July 31, 1997

RE: CONCEPTUAL DRAINAGE PLAN FOR A.O.G. DISTRICT OFFICE (D13-D1G)
ENGINEER'S STAMP DATED 7/23/97

Based on the information provided on your July 24, 1997 submittal, the above referenced site is approved for Site Development Plan approval.

Sheet Title
CONCEPTUAL
Grading and Drainage Plan

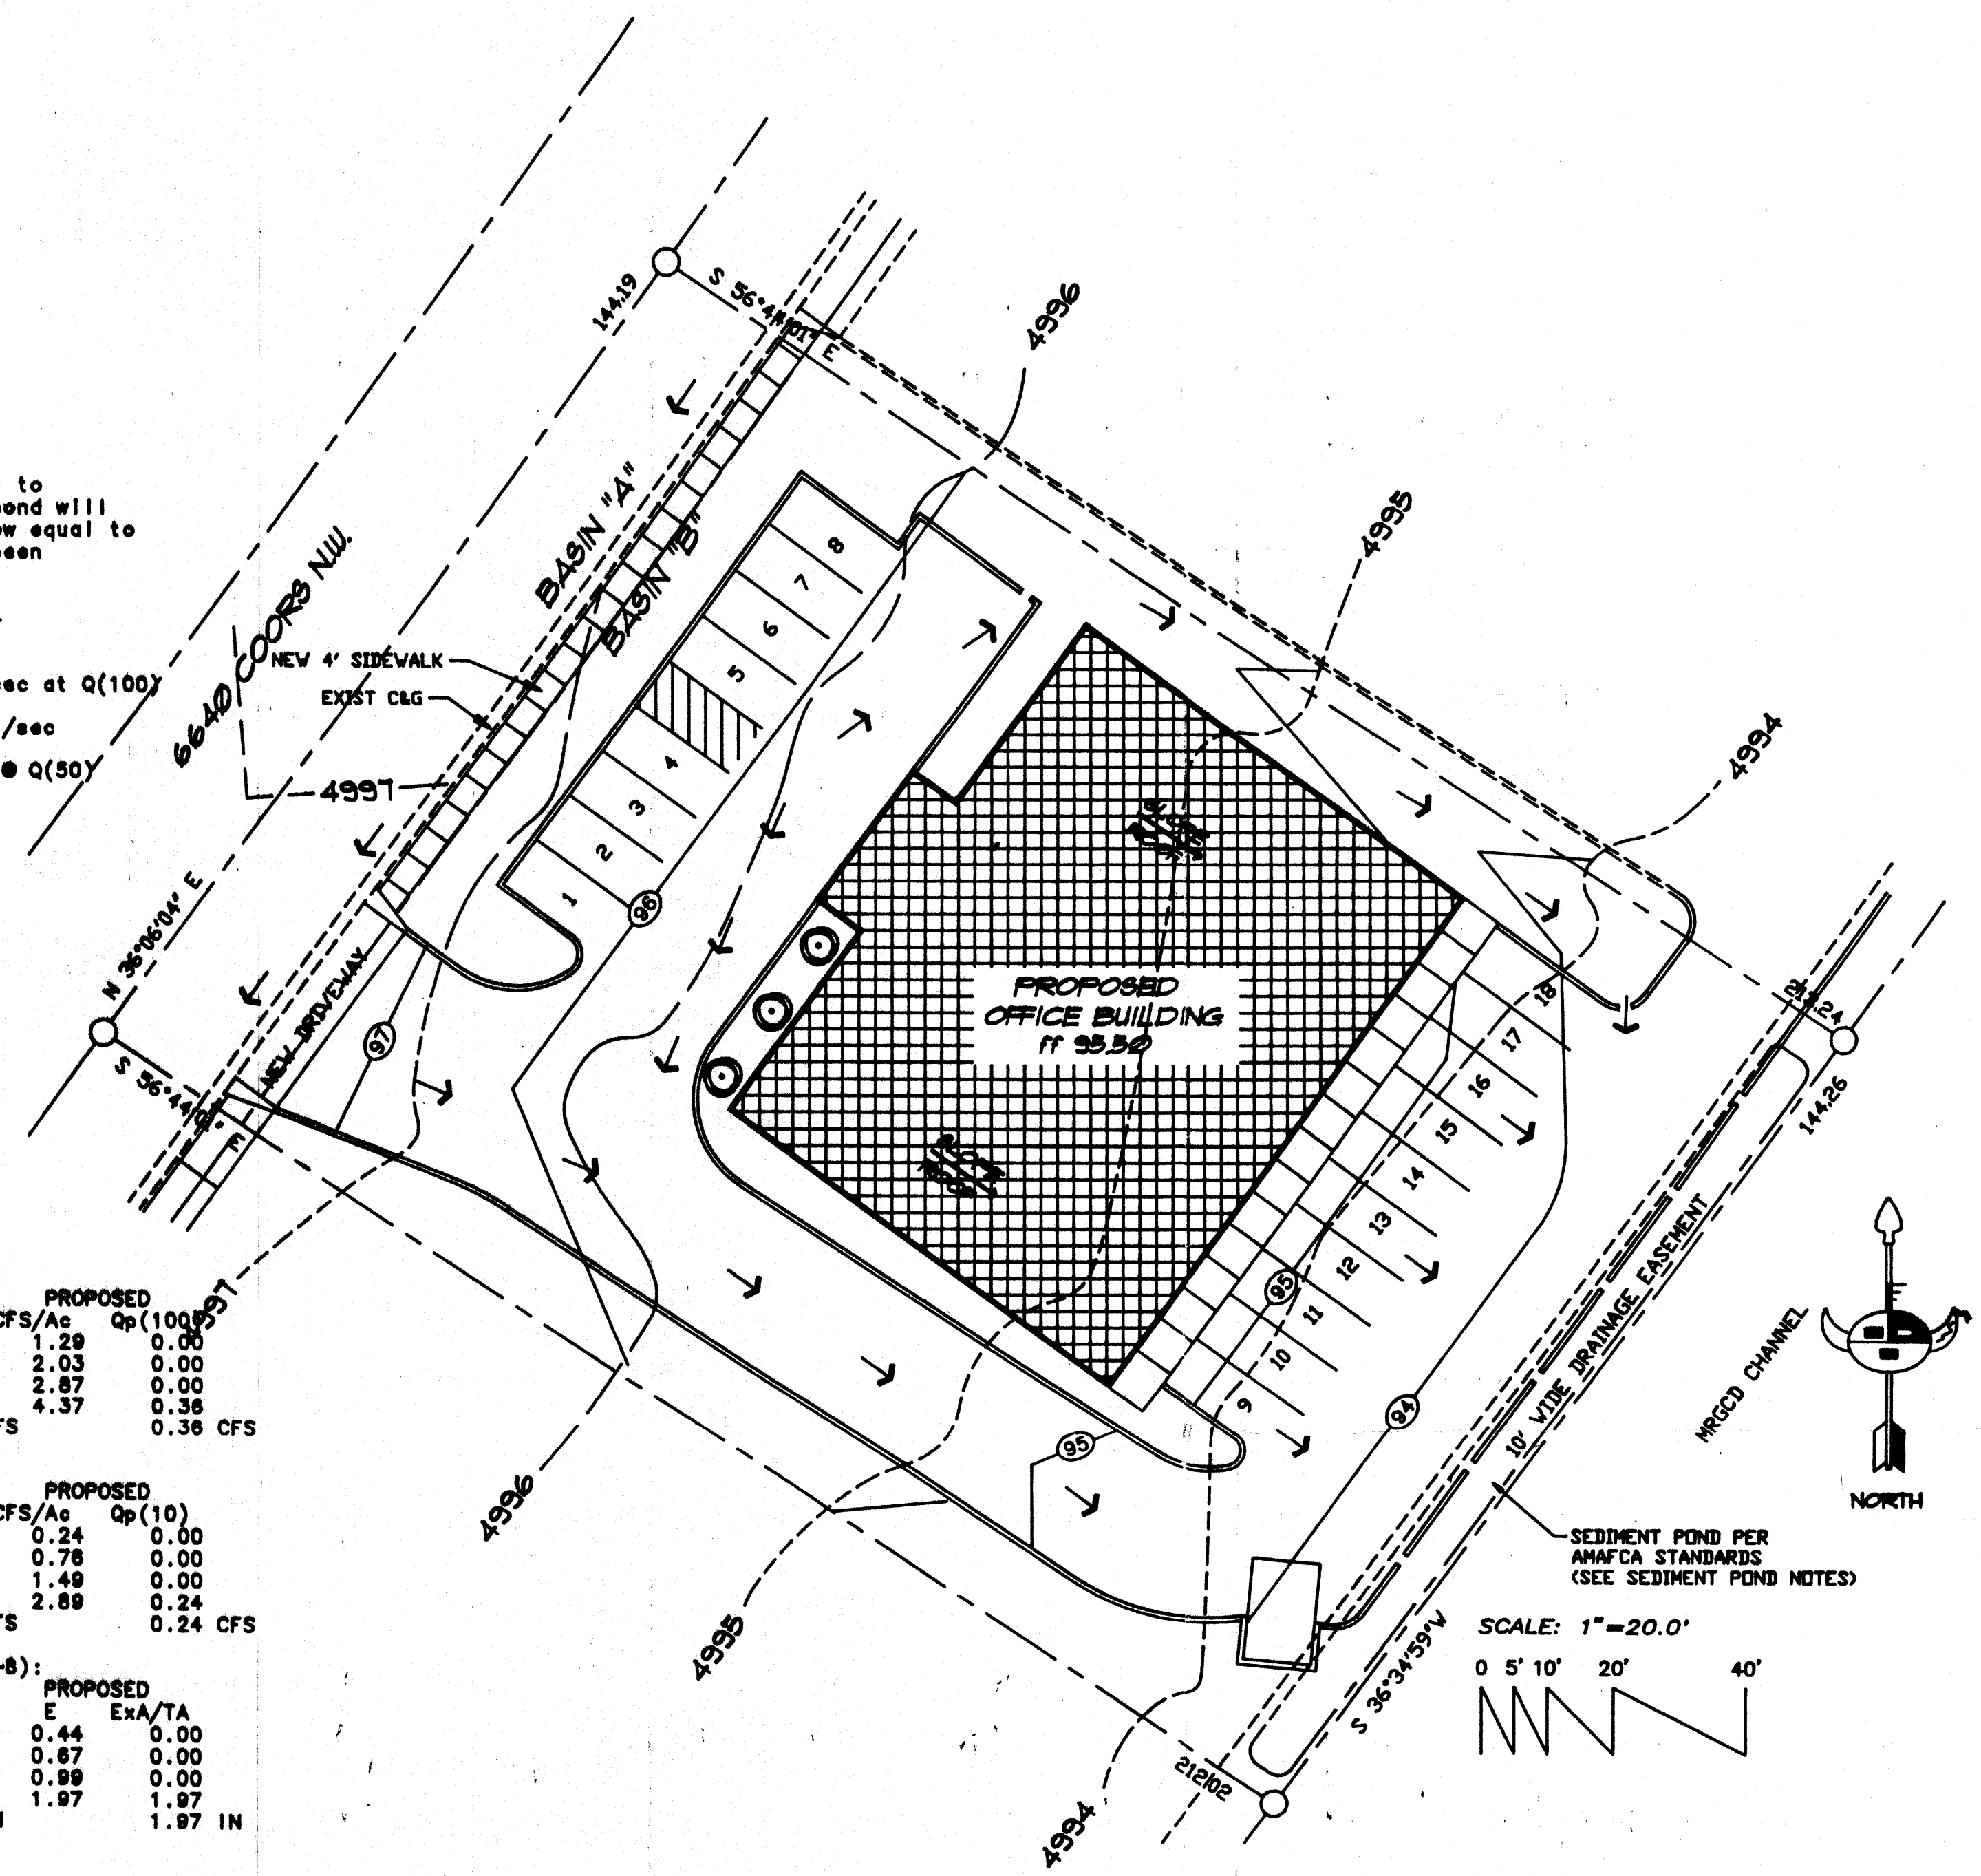
1. Sediment pond design and calculations.
2. Signature block for AMAFCA's approval.
3. Agreement and Covenant must have started the process.
4. Roof downspouts on the east portion of the building should be routed under the sidewalk.
